Please ask for: Nicola Moore
Email: nicola.moore@arun.gov.uk
Telephone: Ext 37944
Our Ref: AW/49/21/HH
Your Ref:
Date: 15th February 2021

Application for Planning Permission for Works or Extension to a Dwelling

Development: Kitchen extension
Location: 10 Wyde Feld Bognor Regis West Sussex PO21 3DH

PROPOSED SINGLE STOREY EXTENSION AT 10, WYDE FELD, ALDWICK

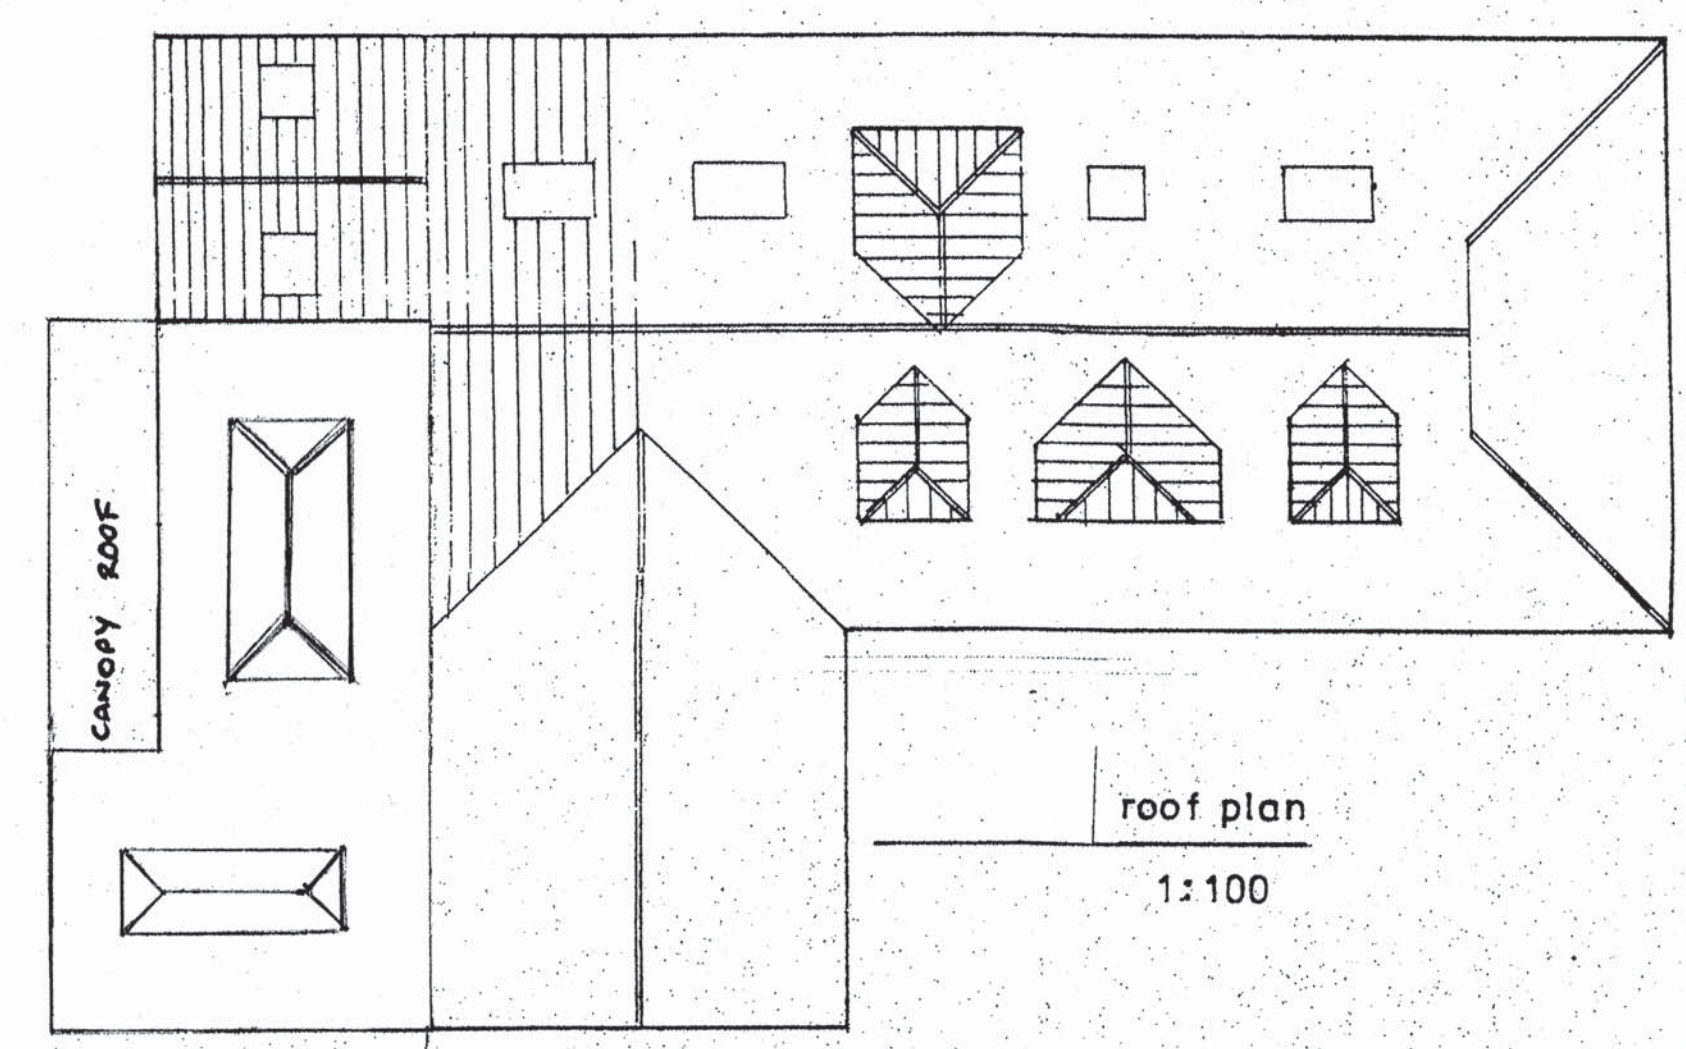
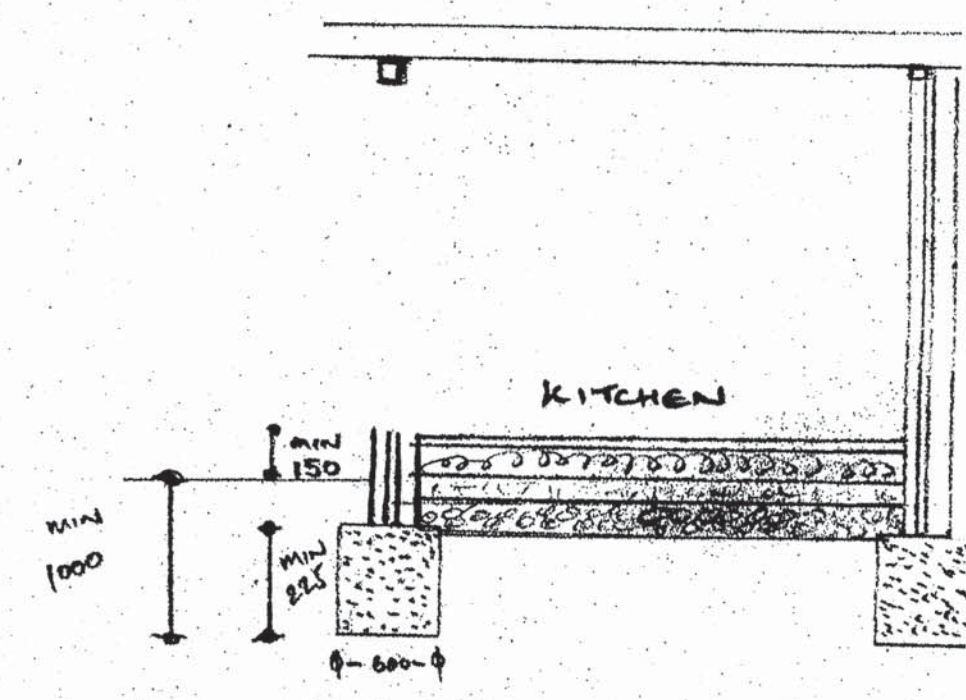
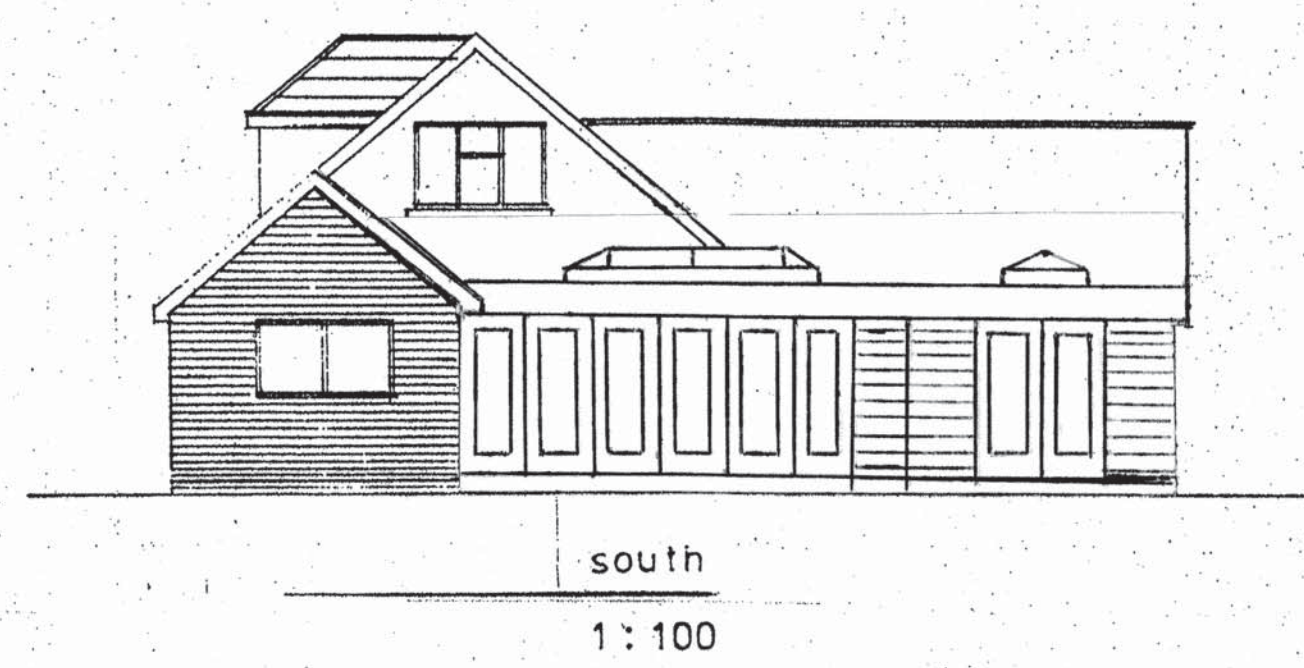
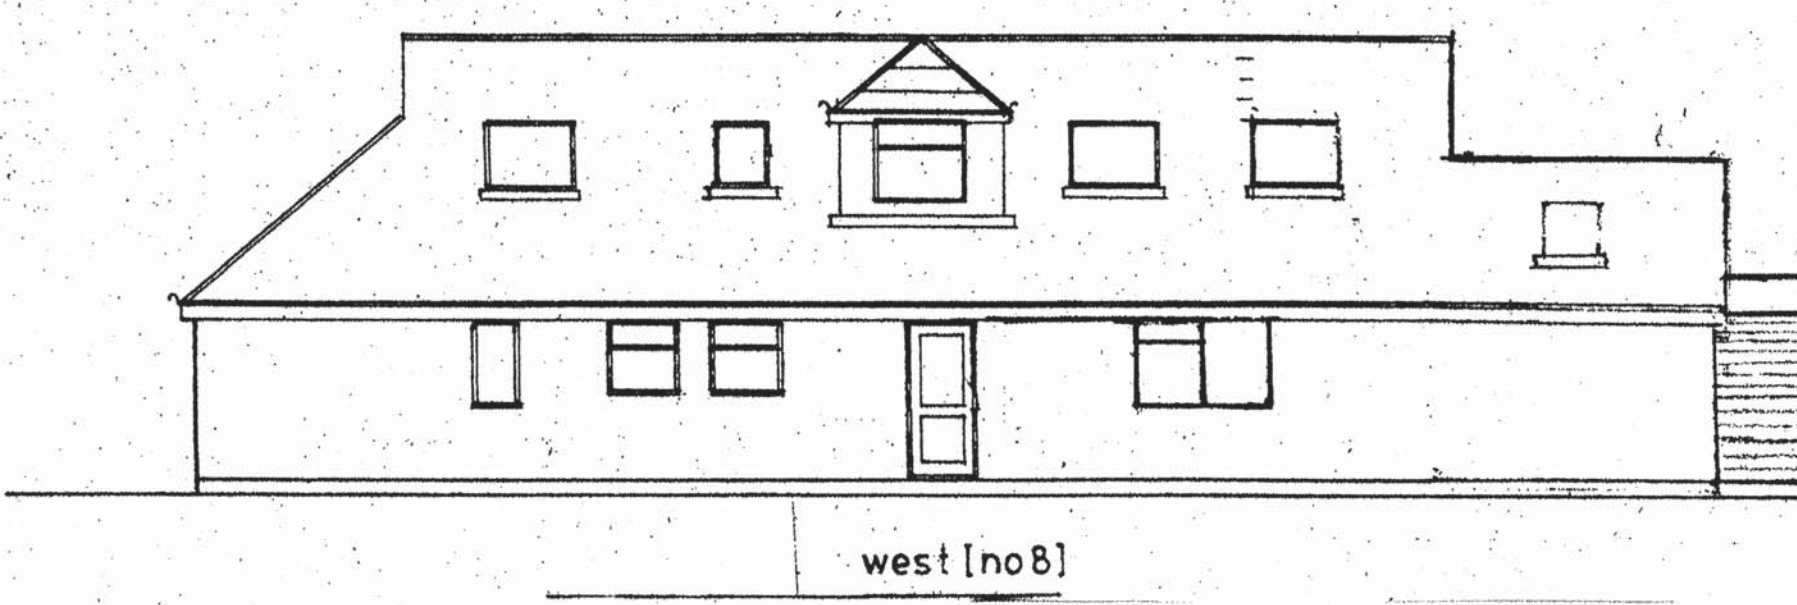
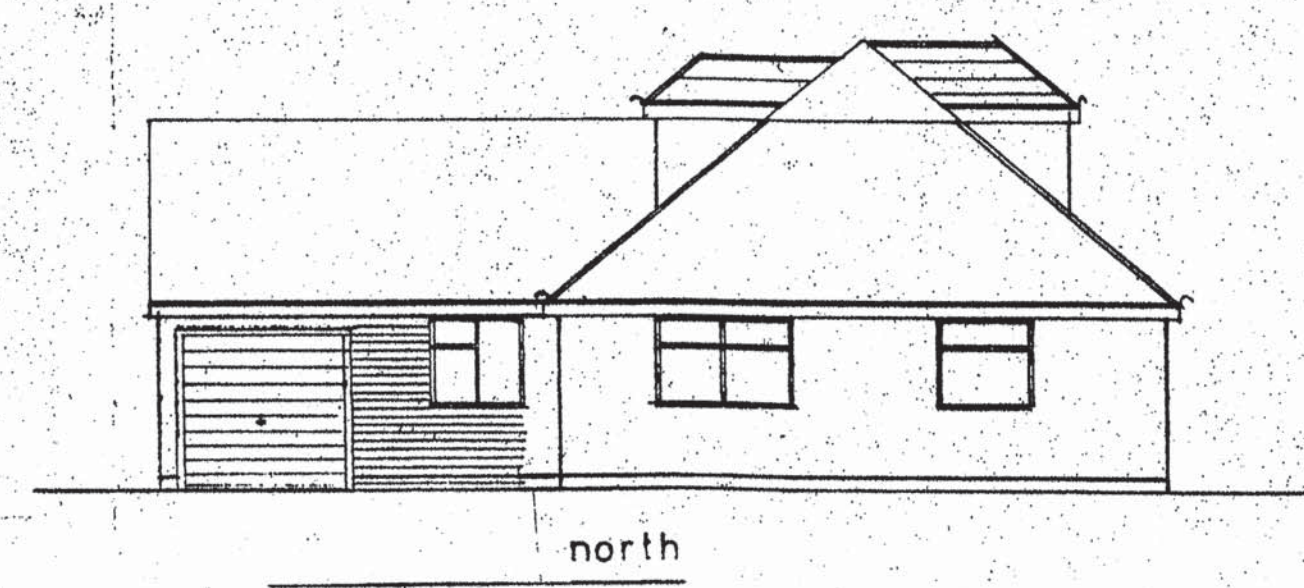
I have checked the measurements on the Proposed extension and there are to be some discrepancies:

Bi fold door = 5.2m on Proposed Floor and 5.7m on Proposed Elevation

Window 1 = 2m on Proposed Floor and 1.69 on Proposed Elevations

Window 3/Door = not clear on Proposed Floor Plan and 1.48 on Proposed Elevation

Please check the measurements, amend accordingly and re submit.

location plan
1:1250

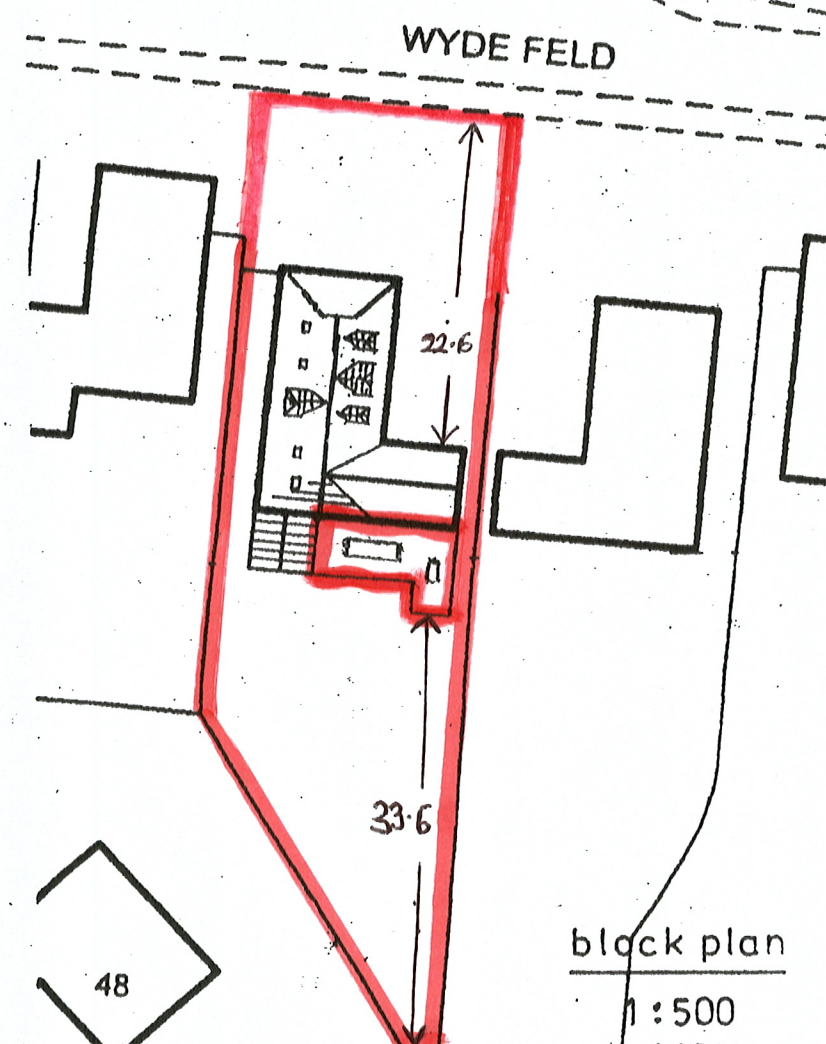
The application site must be edged clearly on red. Please amend accordingly and re submit. Further details of what must be included on the plan can be found in the Validation Requirements List.

Ground floor plan
1:50

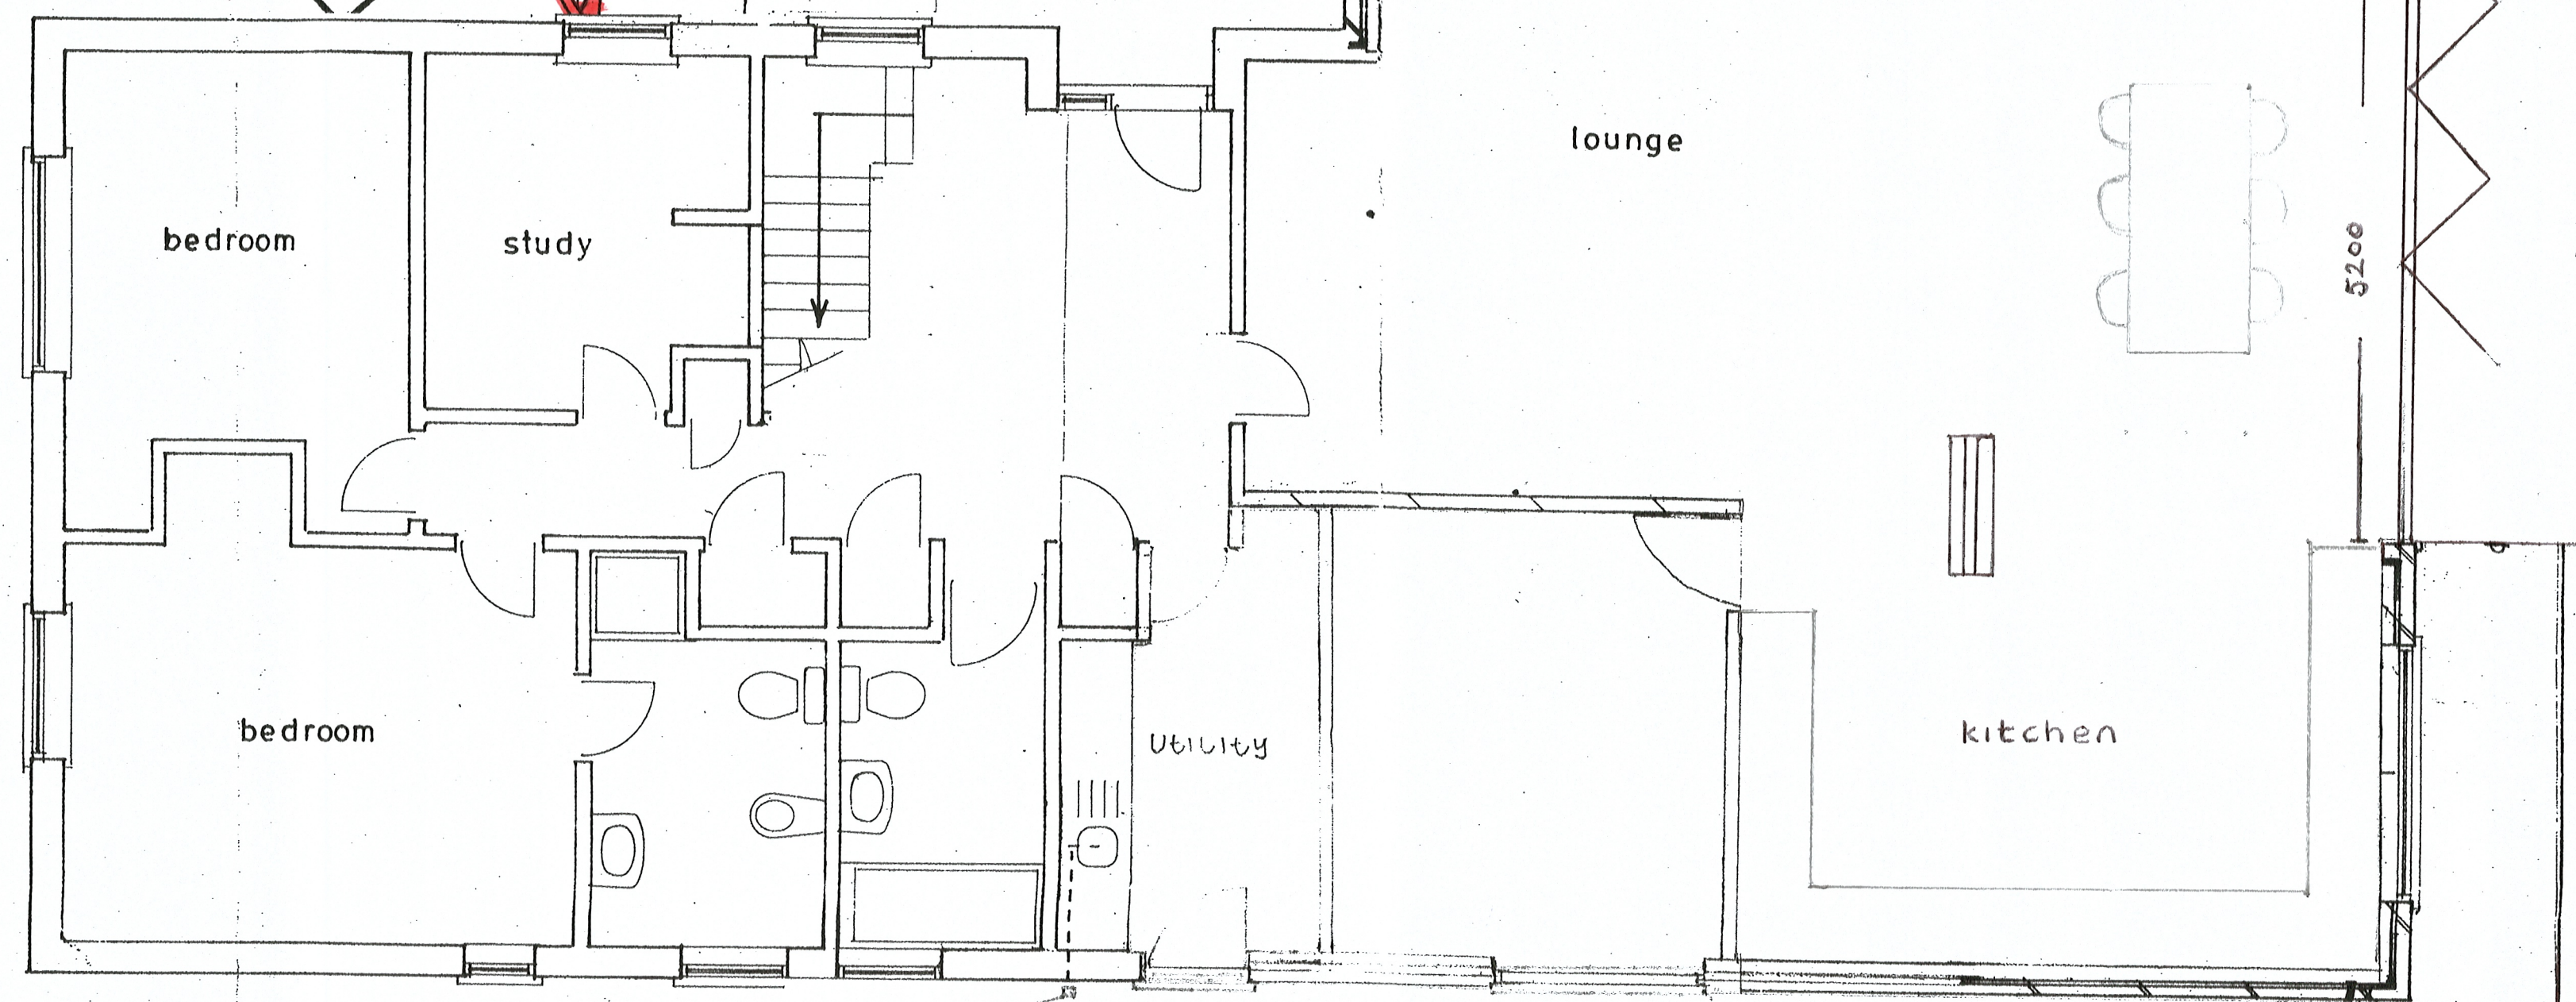
The outline of the proposed extension on the submitted Proposed Floor Plan is not clear. Please re submit ensuring the plan is clear.

block plan
1:500

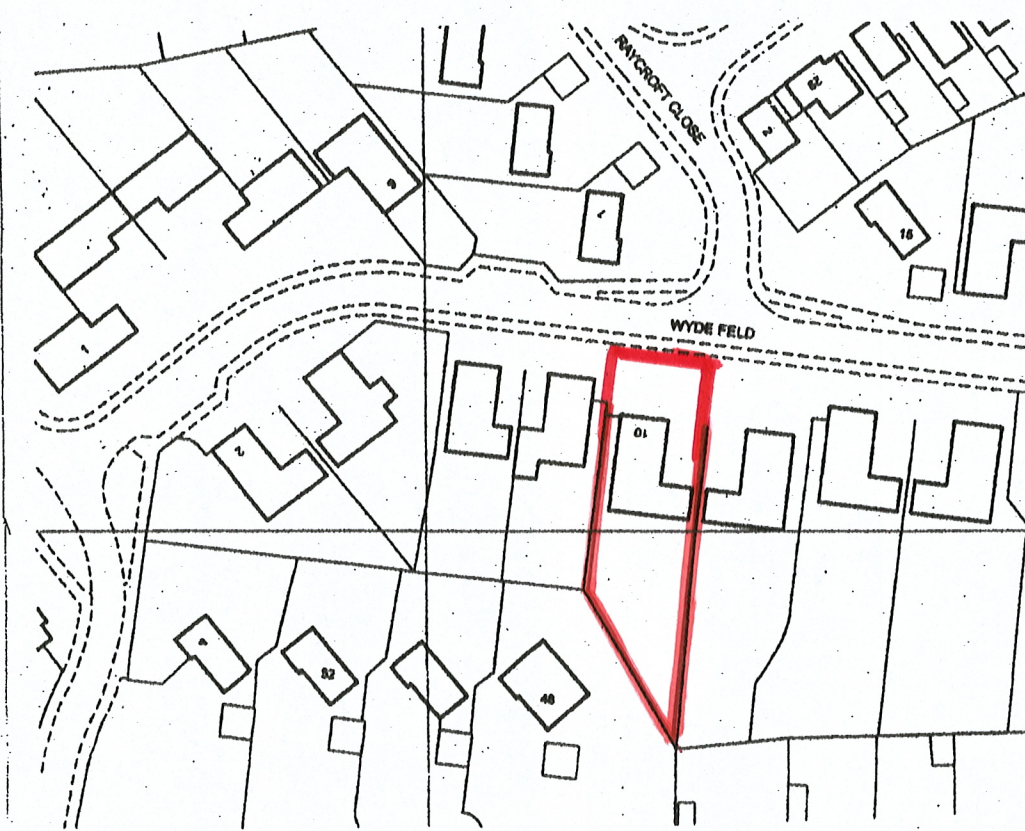
Written dimensions to boundaries are required from the proposed extension. Please amend accordingly and re submit. Further details of what must be included on the plan can be found in the Validation Requirements List.
